Application number: 2024/91008	
What is the application for?:	Variation condition 1 (plans) on previous permission 2023/90909 for reserved mat
Address of the site or building:	adj, 115, Westfield Lane, Wyke, BD12 9LY
Postcode:

NOTES

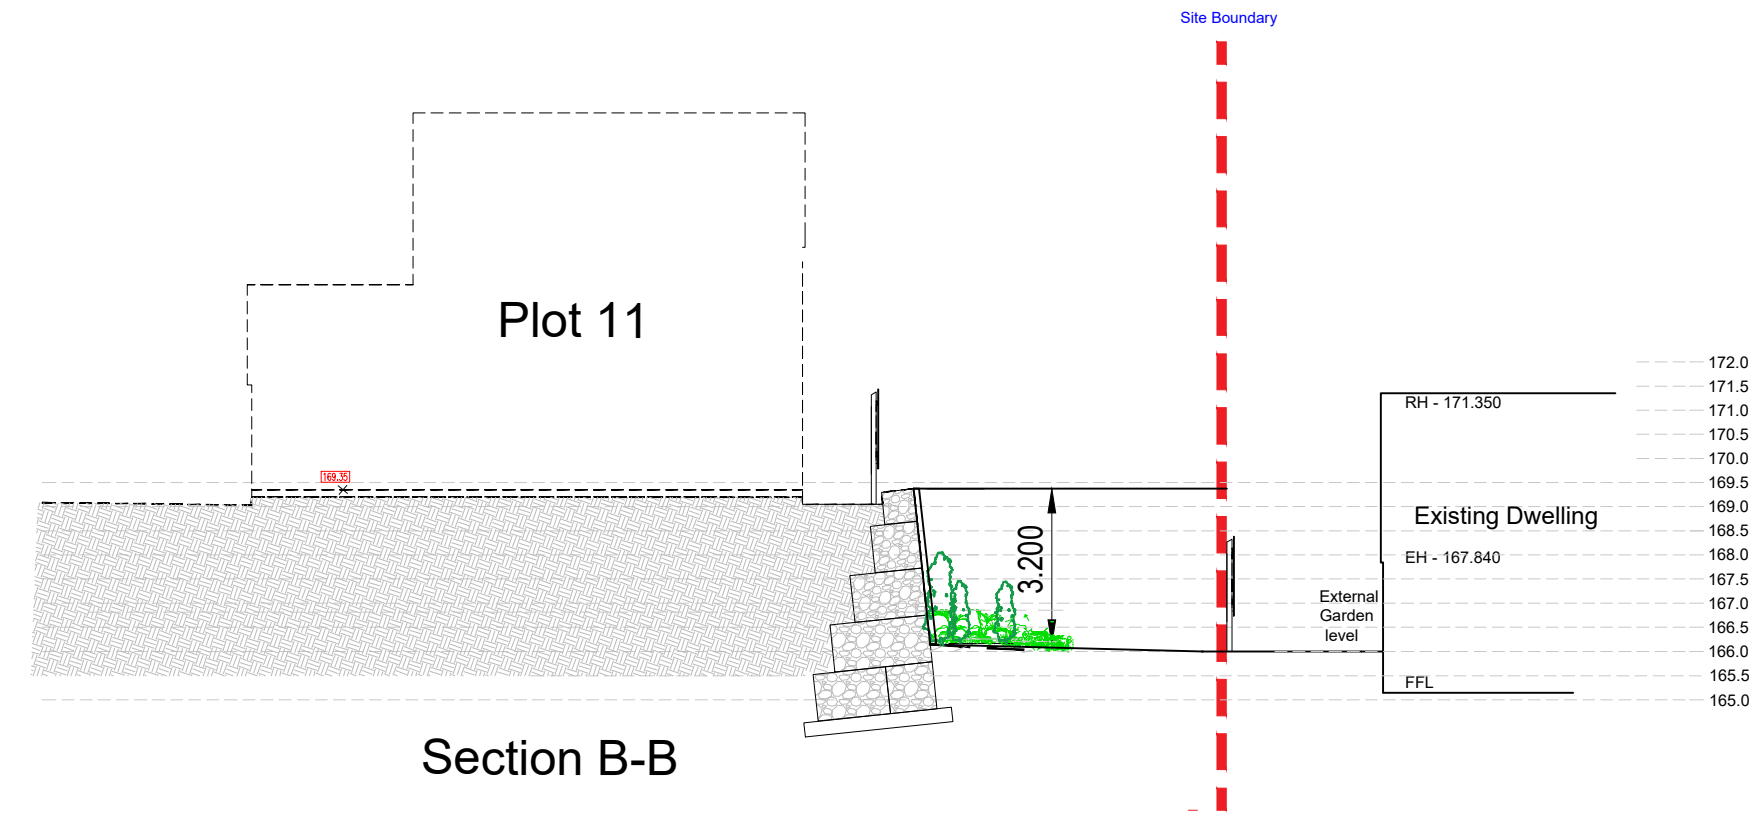
Type of comment: An objection	
Do you wish your comments to be published on the website anonymously?	Yes
May it be noted this is a retrospective application as the wall already built is much higher and much longer then the original plans. Where were building control when this took place? I object to the ammendment for the following reasons: Conservation of the natural environment / effect on trees and the landscape - a 3 metre wall is impassible to ground dwelling wildlife like hedghogs. They can only now access the development via the road. Further trees with TPOs are being removed and "trimmed" in order to "make a better development" these trees were here when orginal plans submitted. Had these "ammendments" been proposed at the start the development would not have been approved. Yet another backhand and backdoor way of getting things passed, shameful Kirklees for approving. Now this T2 tree is considered newly dangerous ? Why ?Damage by construction process. Any follow up / financial implication because of this? On the original application (now confusing due to the sheer number of ammendments and further applications) an environmental impact financial contribution was mandated. Is this still the case? Please address, how much and where being spent and insure this is occuring in Scholes. I object also to design, appearance and layout effect on the character of an area / privacy of neighbours - houses are raised on a 3 metre platform making them equivalent of 4 story house that overlooks neighbours directly. The retaining wall is not in keeping with the landscape. The long left side has no planting planned. And once planted who will maintain as they will have to use other peoples property to access as this cannot be accessed from inside the development due to the 3m drop.
